PLAN REVIEW SHEET

Petition #: RZP 2021-045

Address: 13316 Mallard Creek Road

Request: R-17 MF (CD)

REZONING PETITION #2021-045
FOR
MALLARD CREEK APARTMENTS
CHARLOTTE, NORTH CAROLINA

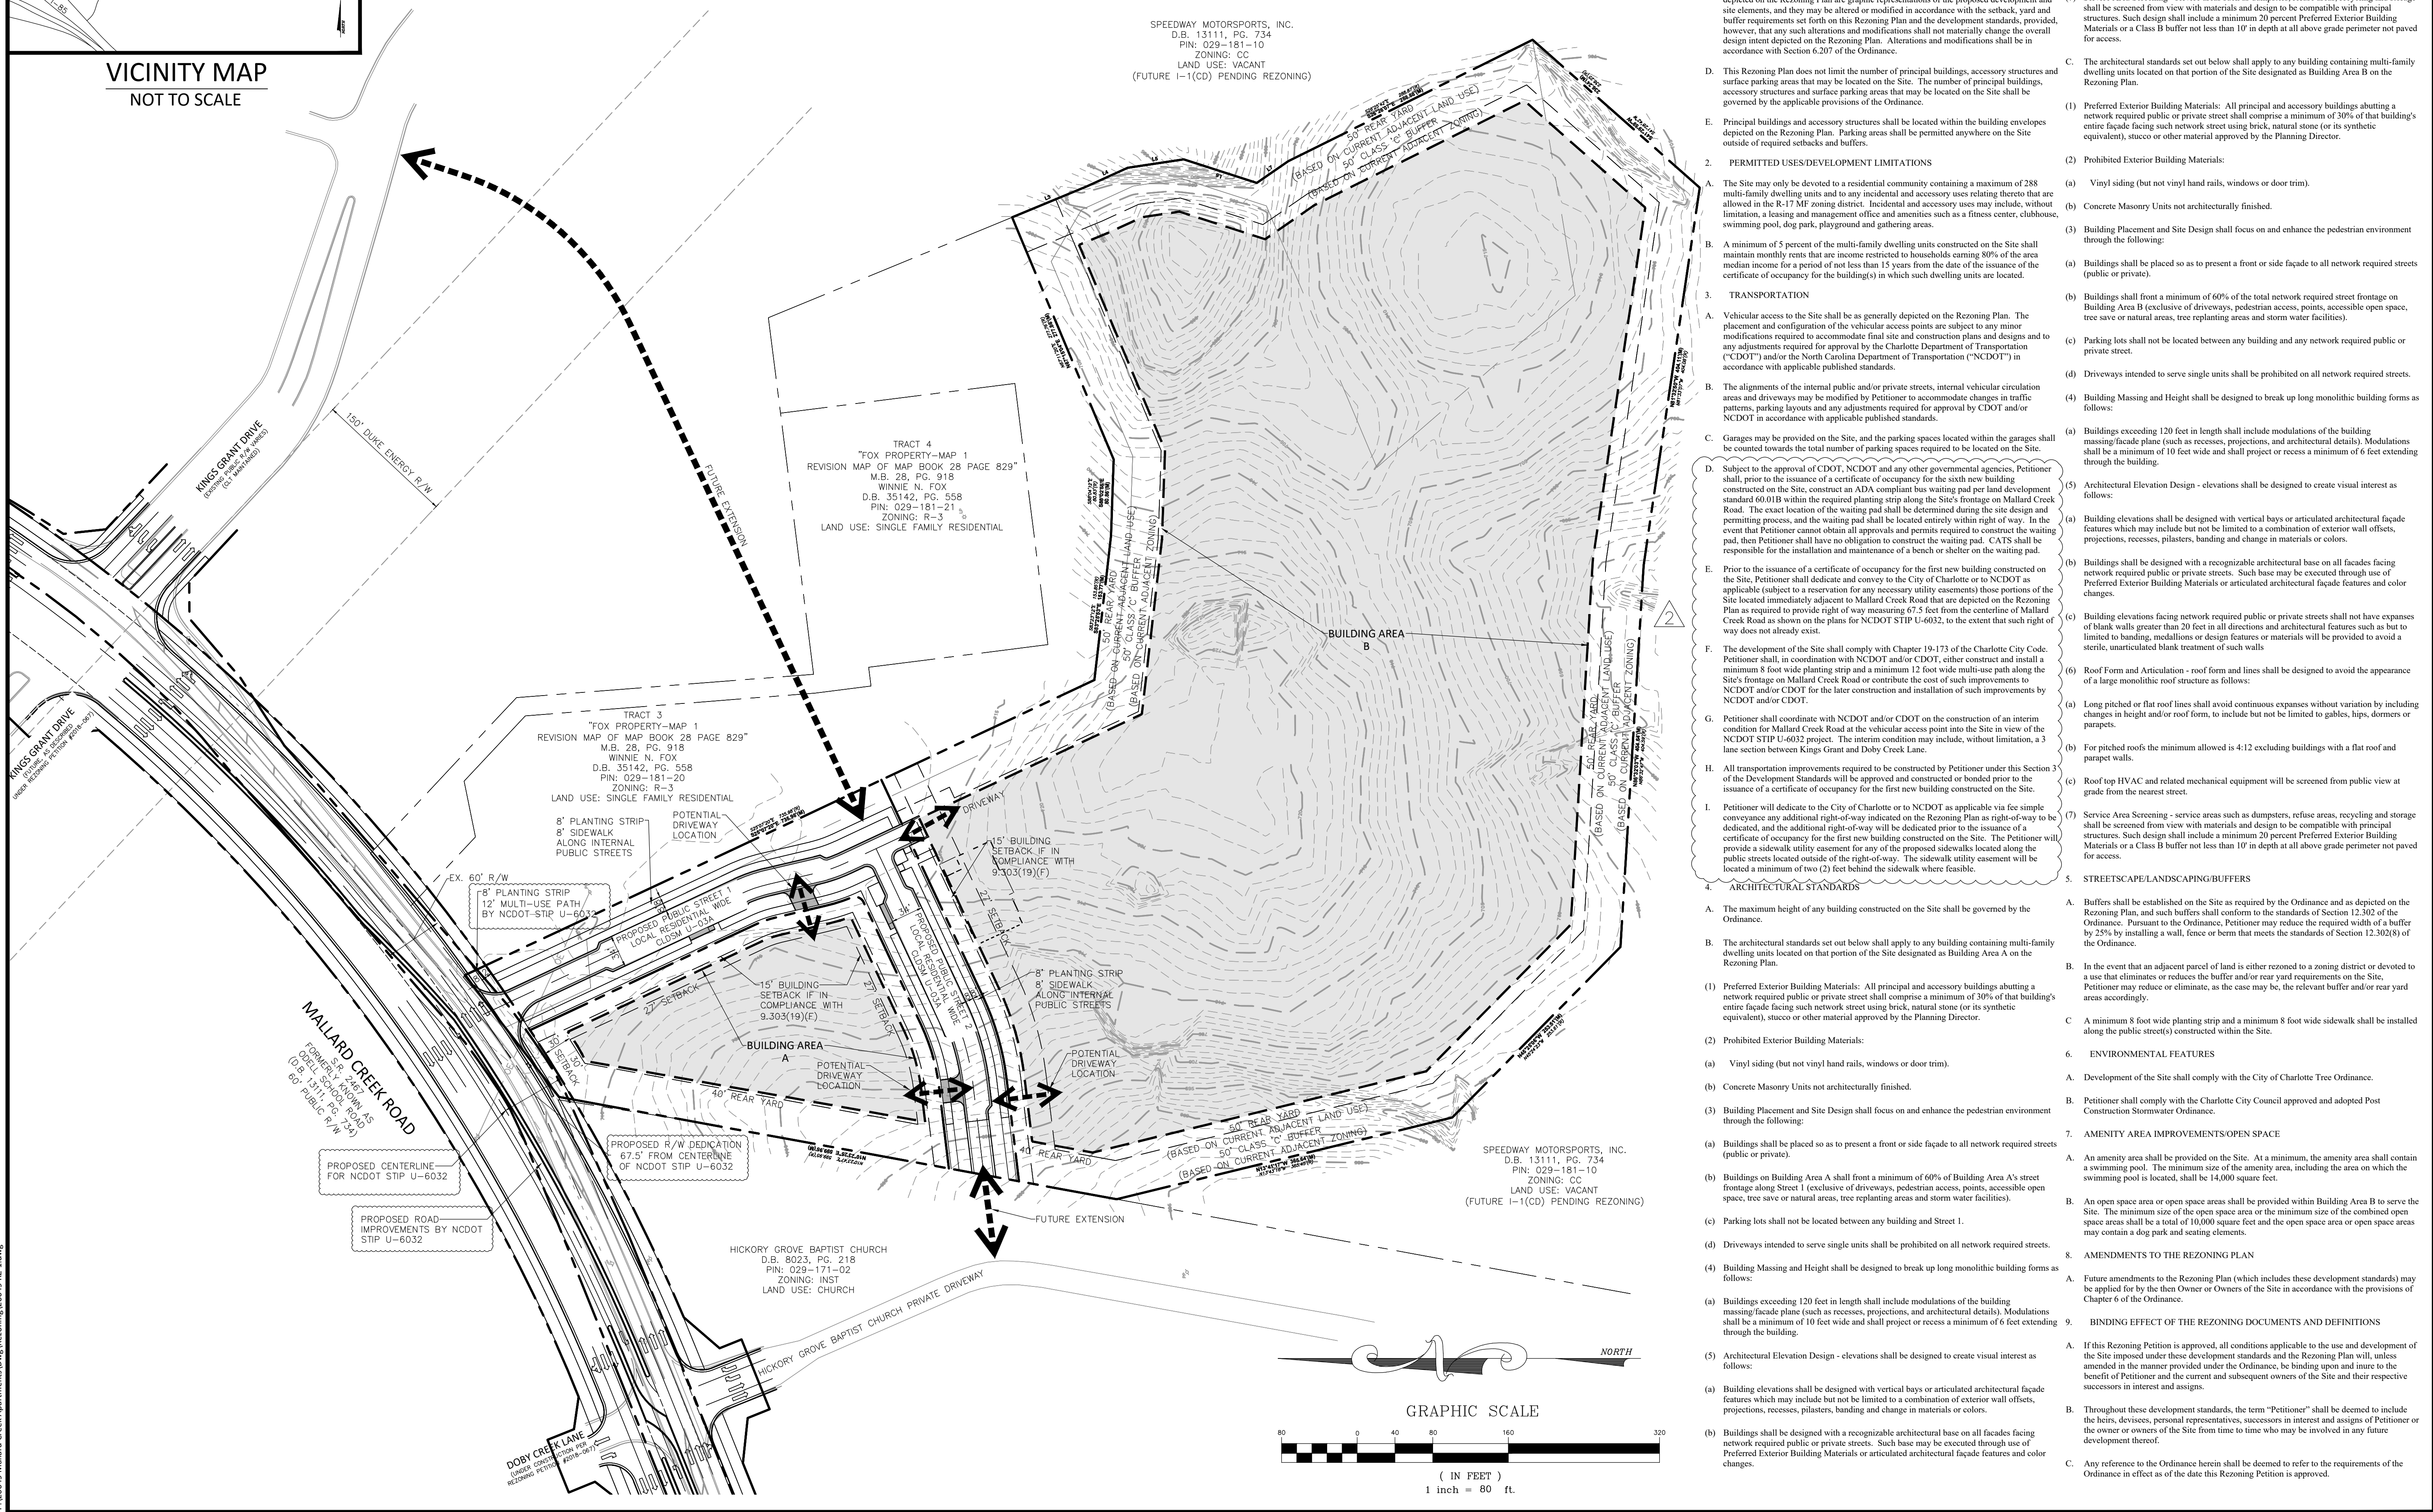
The site is located along the CATS #54 local bus route. CATS requests the construction of an ADA compliant bus pad per Land Development Standard 60.01B on Mallard Creek Road. The final location of the pads will be coordinated with the developer through the permitting process.
